# EPC DPW Stormwater\_2026-06-10\_004 - GEC Plans.pdf Markup Summary

## [45] G-1 GEC Cover Sheet (3)

G-5

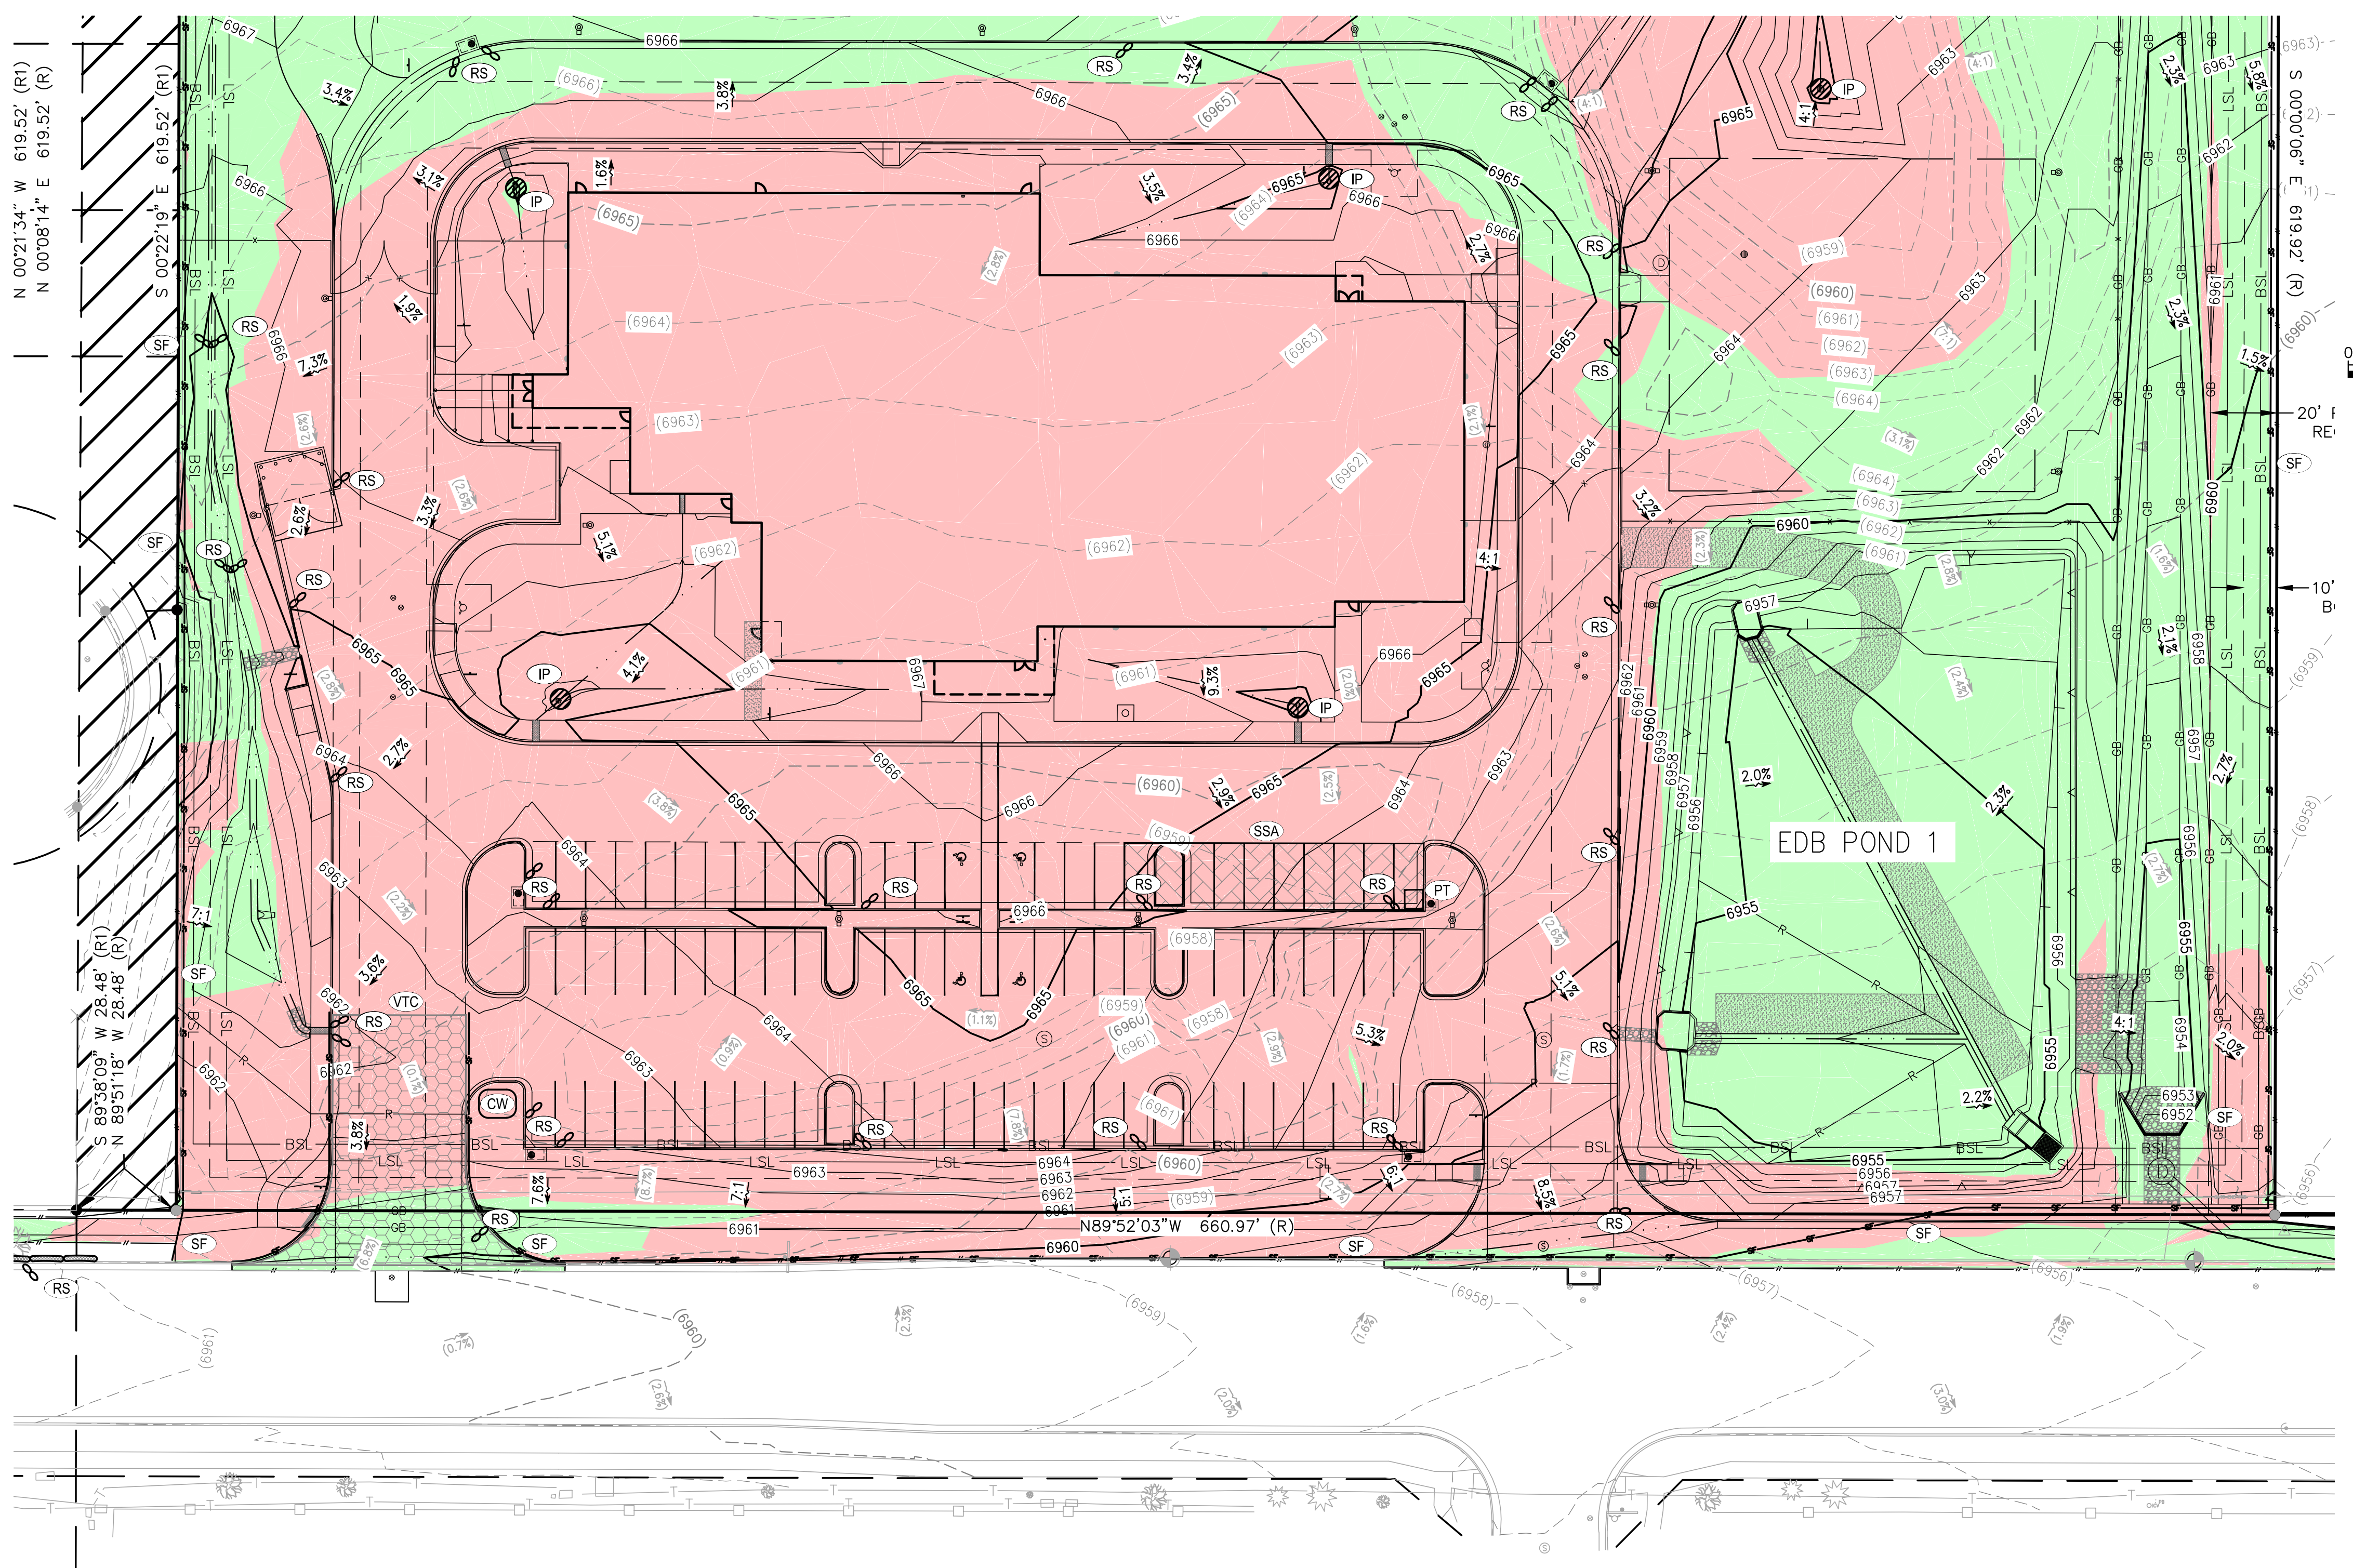
GEC Checklist item O. Show proposed areas of cut and fill.

TAIT Response: Added hatched area to show cut and fill.
